The Sizewell C Project, Ref. EN010012

Comments on any additional information/submissions received at D5

Suffolk County Council Registration ID Number: 20026012

6 August 2021

TEMPORARY COASTAL DEFENCE FEATURE GENERAL ARRANGEMENT

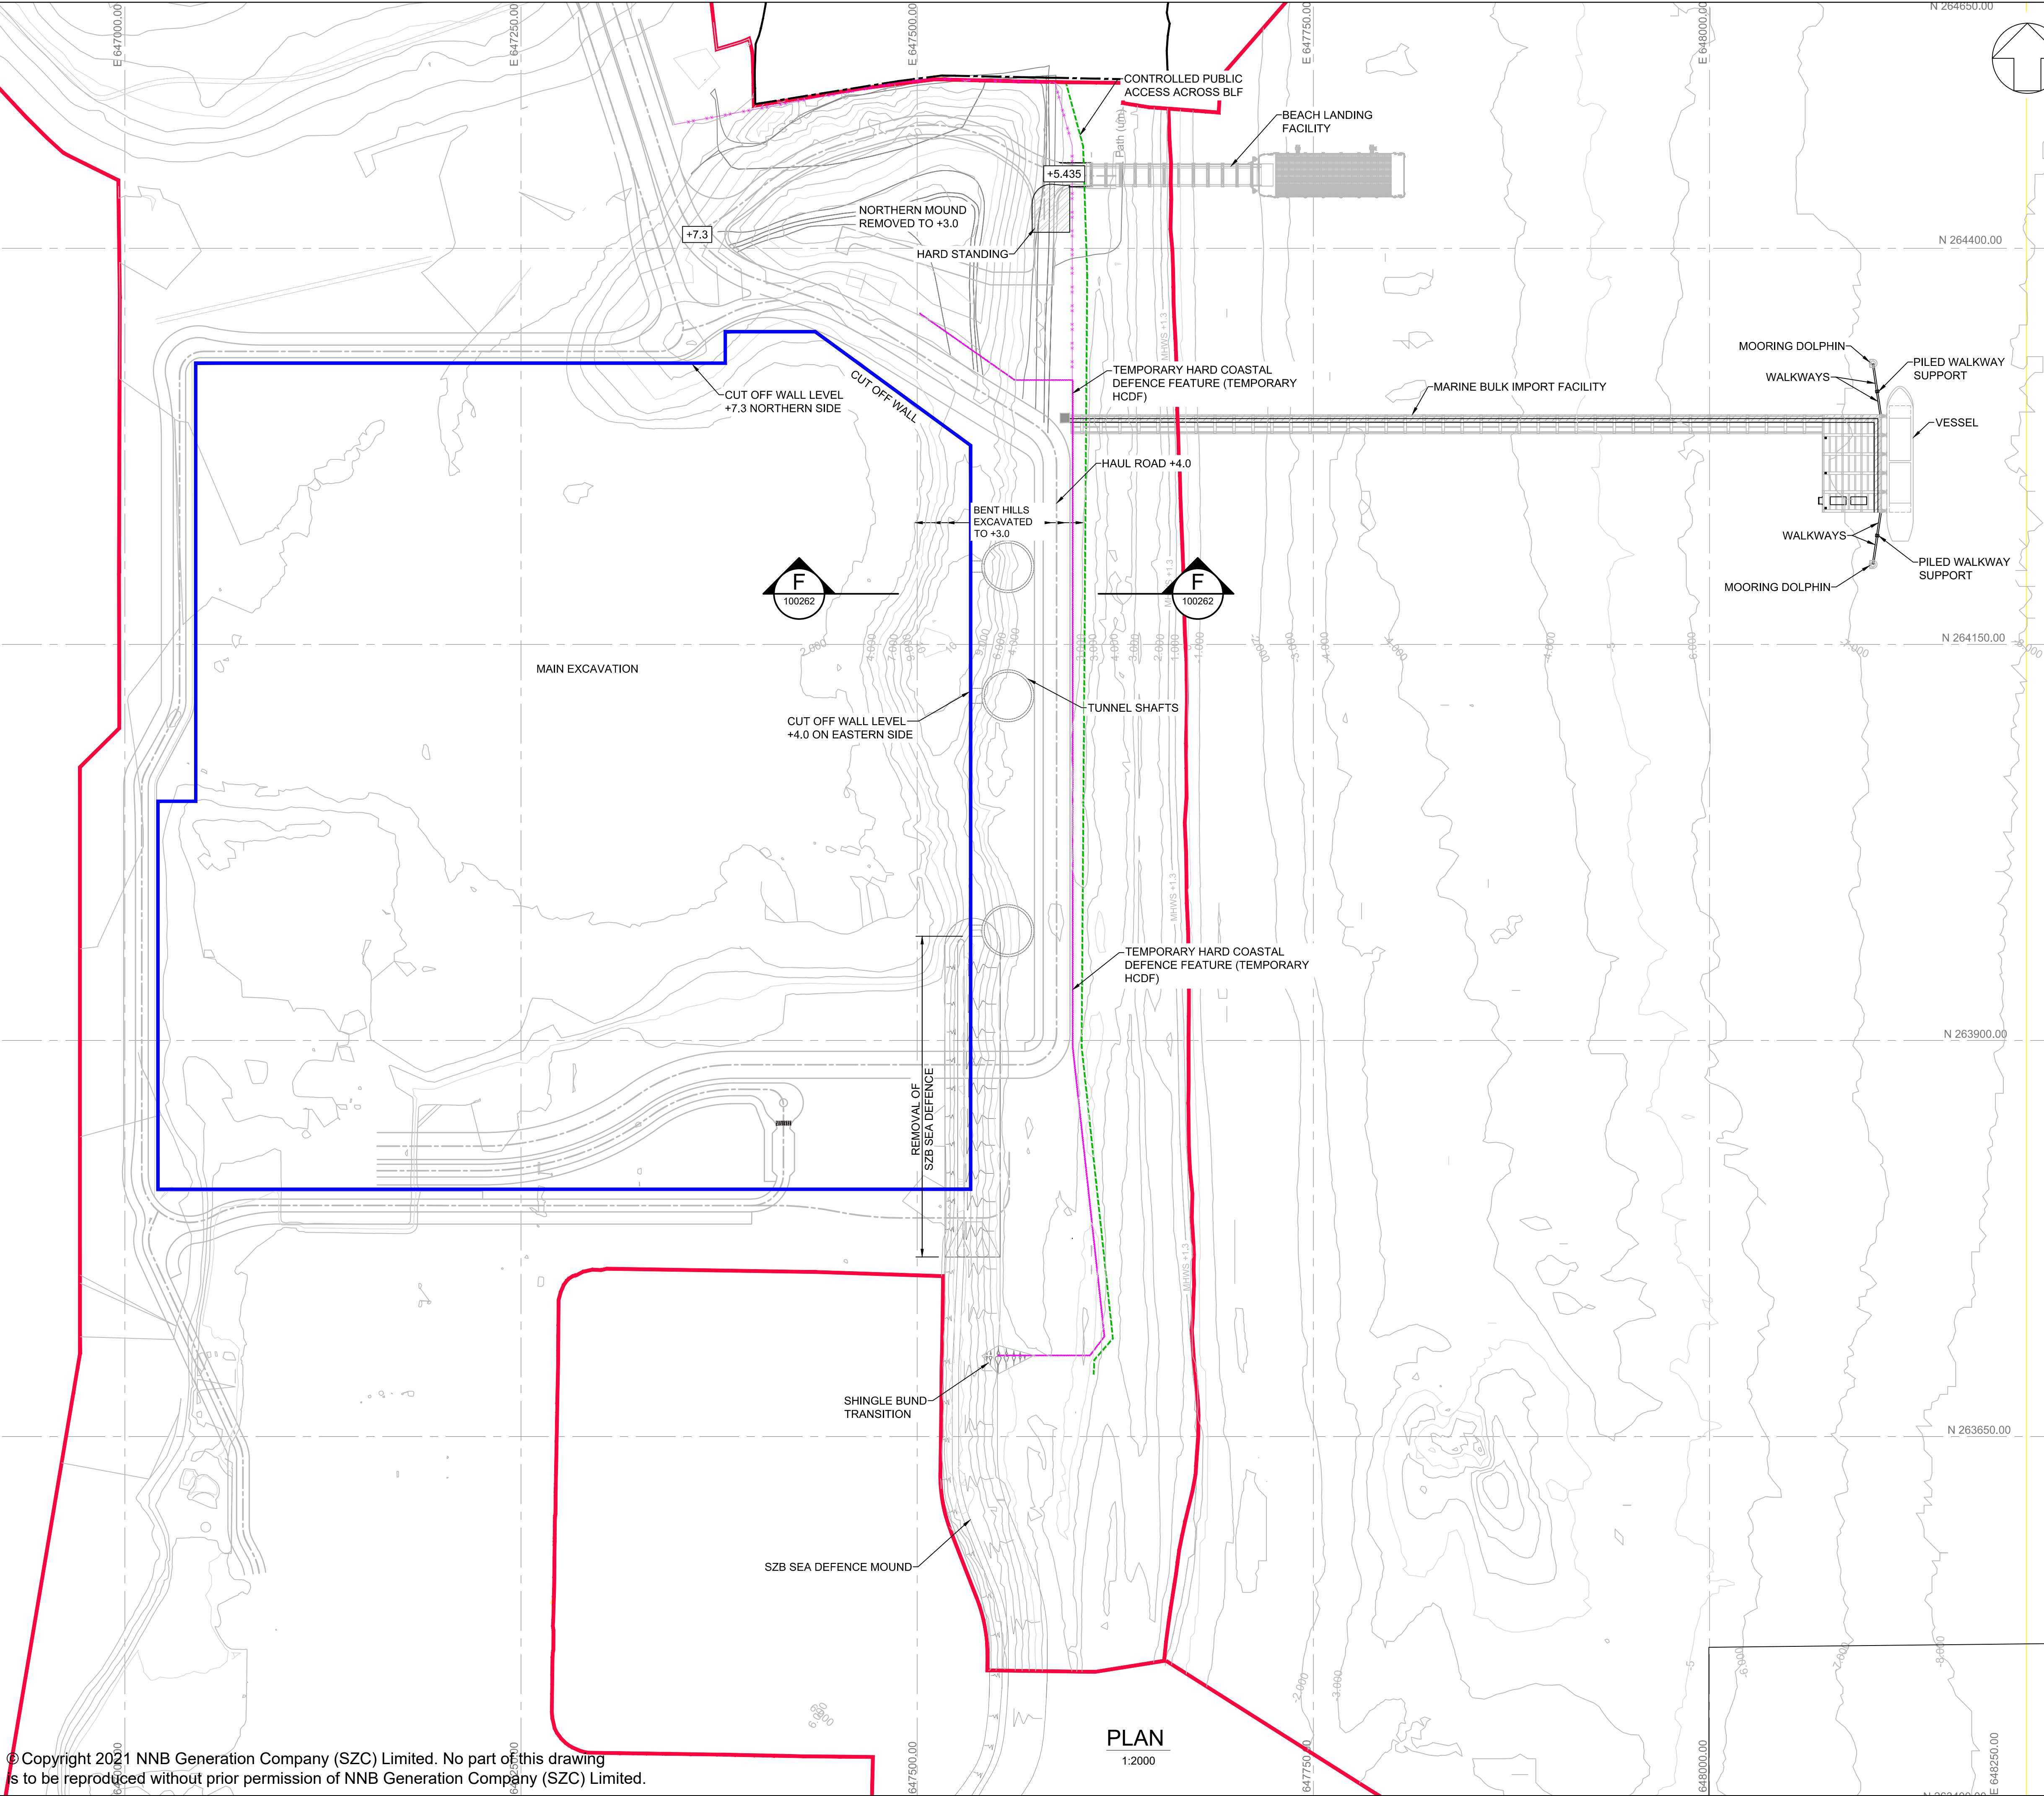
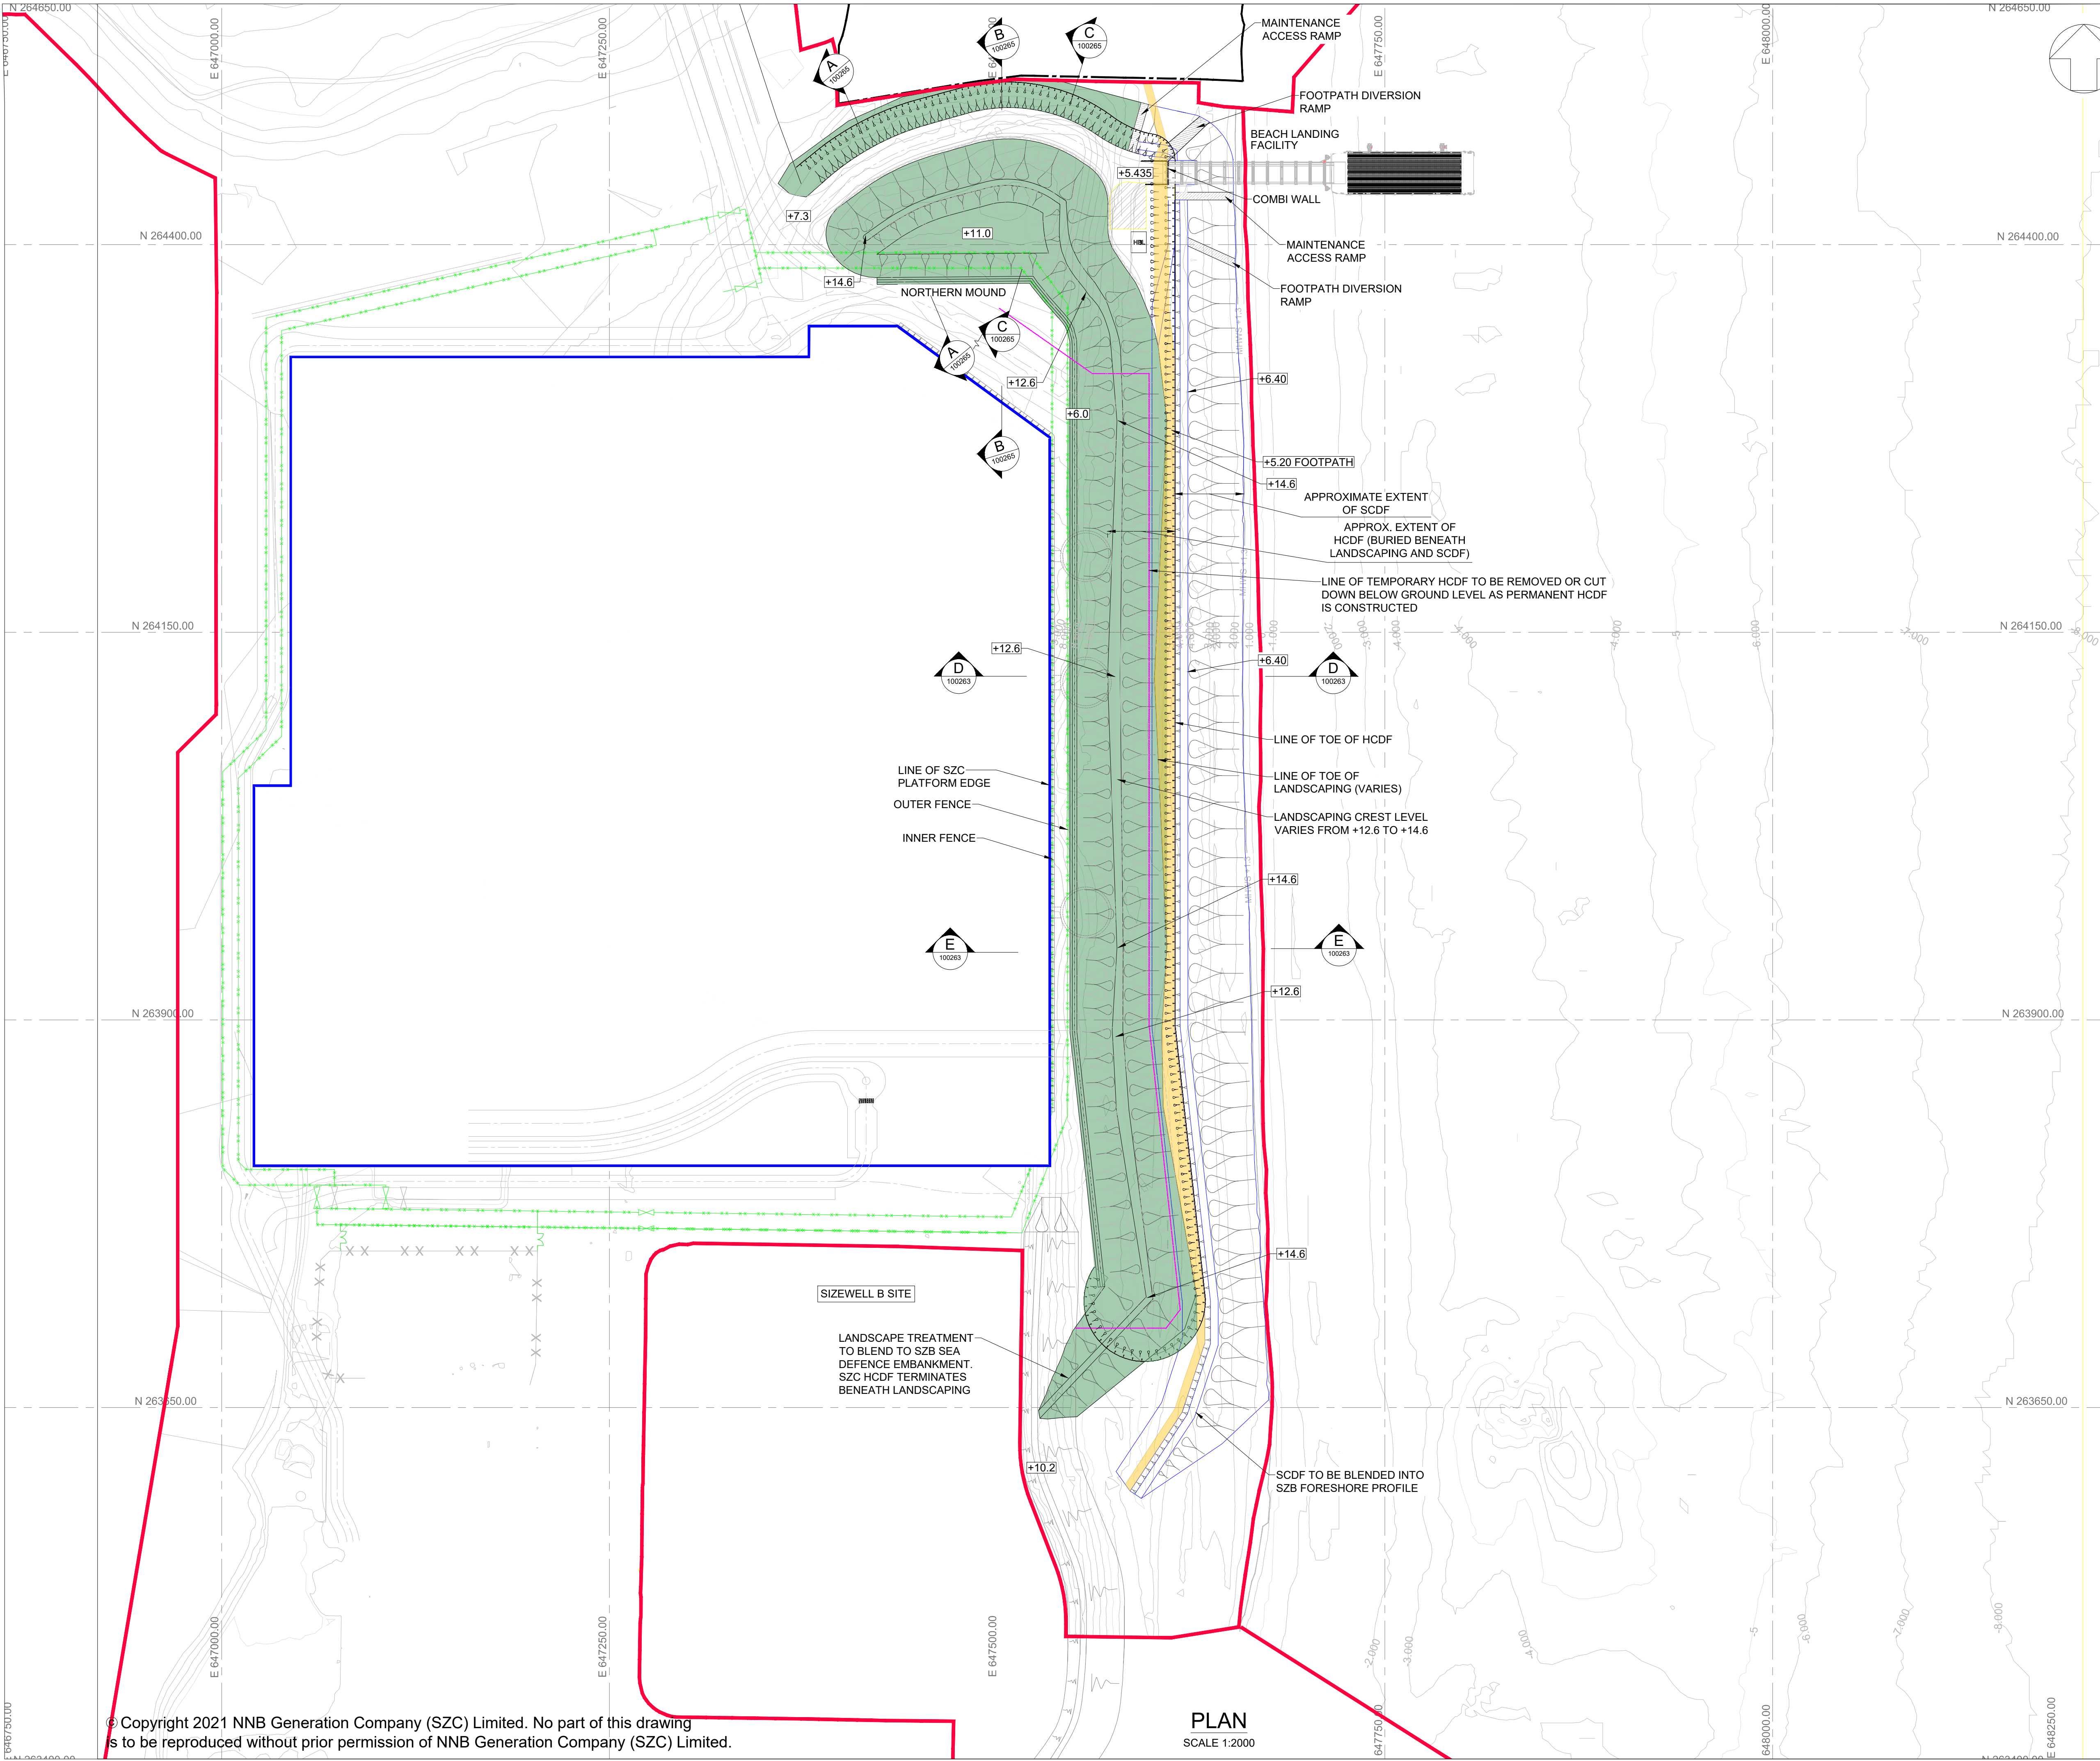
1. Whilst in general, SCC defers to ESC for comments on coastal sea defence and coastal geomorphology issues, we do wish to make the following comment in relation to the coast path.

Ref	SZC Co plans in [REP5-015]	SCC Deadline 6 response	Ref to other submissions
2.5 Temporary and Permanent Coastal Defence Feature Plans - Not for approval - Revision 2	Deadline 5 Submission - 3.1(D) Draft Development Consent Order - Tracked Changes Version Revision 5 against Revision 4 - Revision 5	SCC notes in the <u>Temporary and Permanent Coastal Defence Feature Plans - Not for approval rev 1.0 June 2021</u> , the position of the coast path is shown in both the general arrangement and typical section plans, but in the <u>Temporary and Permanent Coastal Defence Feature Plans - Not for approval rev 2.0 July 2021</u> , the coast path is shown in the general arrangement only, and not in the typical sections. The county council has not yet agreed the overall alignment of the coast path but wishes to highlight this anomaly.	Temporary and Permanent Coastal Defence Feature Plans - Revision 1.0 [REP3-004]

Plate 2.1: Phasing Schedule

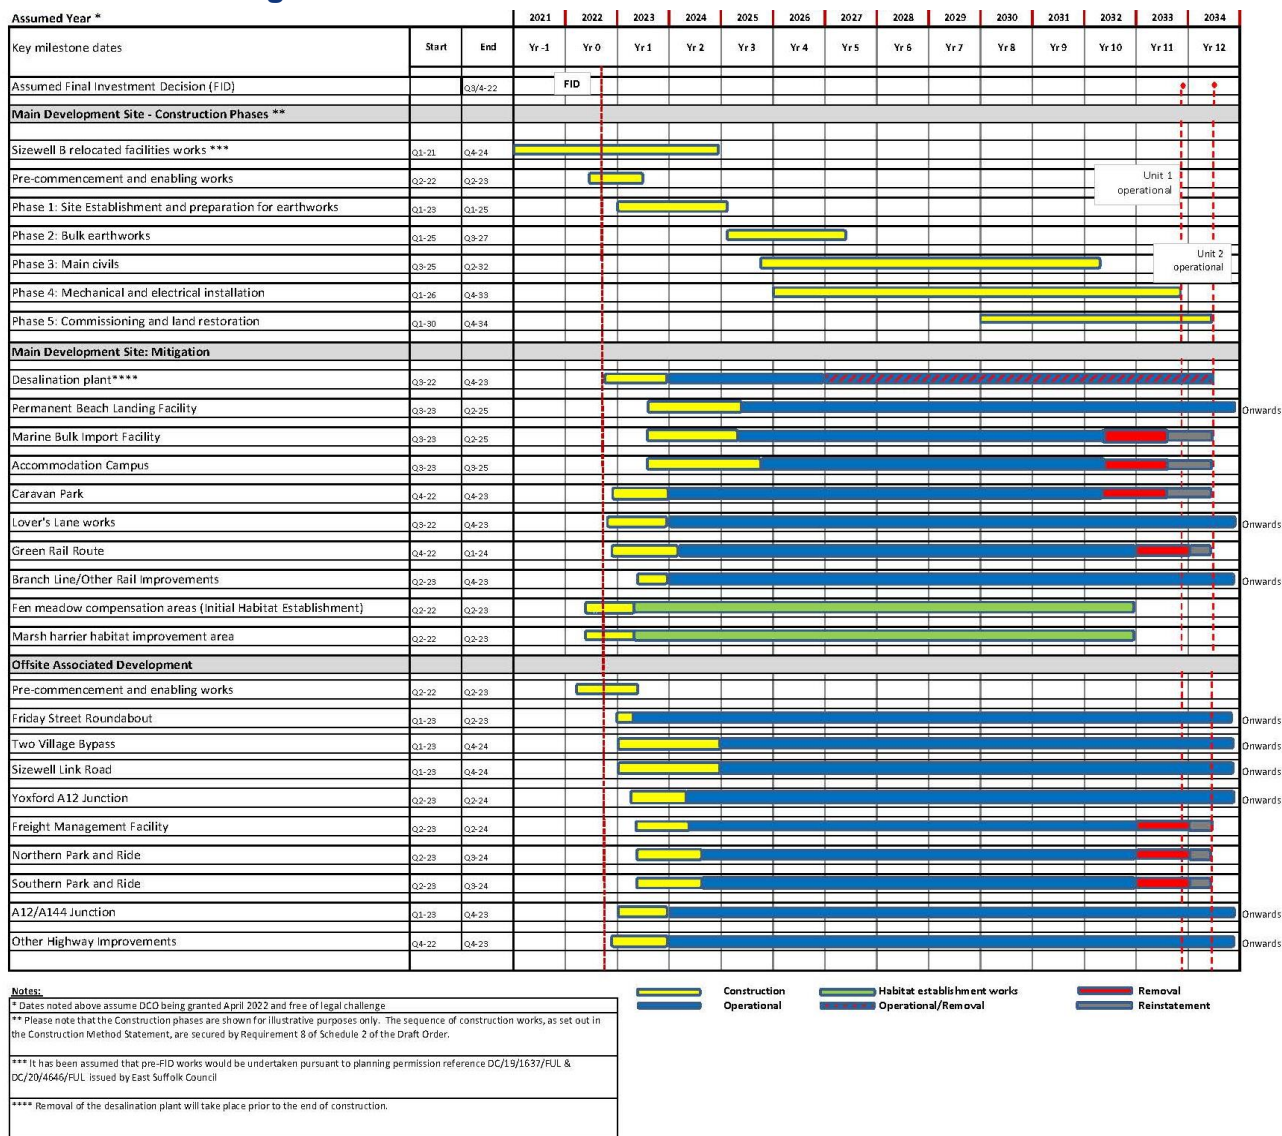
Ref	SZC Co comments in [REP5-058]	SCC Deadline 6 response	Ref to other submissions
Plate 2.1	<p>Plate 2.1: Anticipated construction sequence</p> 	<p>Plate 2.1 indicates the ESL bridge will be completed in Q7 from start of construction i.e. late 2024 according to the implementation plan [REP2-044] and not late 2023 as stated in page 5 of the Materials and Modal Split ISH2 actions [REP5-114] this is a key piece of infrastructure necessary to allow HGVs hauling fill from TVBP to avoid Yoxford</p>

and the B1122 but may not be in place until late in the TVB / SLR construction program.													
Plate 2.1		Does not separate Middleton More link from main SLR which makes it difficult to anticipate how the project will be delivered and at which stage sections will be available for use.													
2.4.17	Where reasonably practicable, the movement of construction material, construction plant and/or construction workers from the temporary contractor compounds to the work sites would be along temporary roads within the area of land required for construction (known as haul routes). These haul routes would be located along the line of the route of the proposed Sizewell link road or running parallel to it.	The statement mentions the use of the haul roads but only for use where reasonably practical. SCC seeks further details on how the haul roads within the SLR site will operate to allow for the movement of fill between the SLR, TVB and main site.													
2.4.20	All HGV construction traffic would use the A12 and B1122 between Yoxford and the new roundabout west of Middleton Moor to access the temporary contractor compounds. The construction of the proposed development is expected to generate up to 100 HGV (each way) movements per day during the construction period (200 movements in total). LGV and cars would use A12 and B1122 between Yoxford and Leiston, depending on origin/home location.	Do vehicle totals allow for movement of fill to main site or are these included in main site movements? Although SCC requests clarity on this it does welcome the proposals to include all SLR, main site and park and ride bus movements as HDVs capped on the B1122 in the early years.													
Table 2.2	<p>Table 2.2: Anticipated material quantities</p>
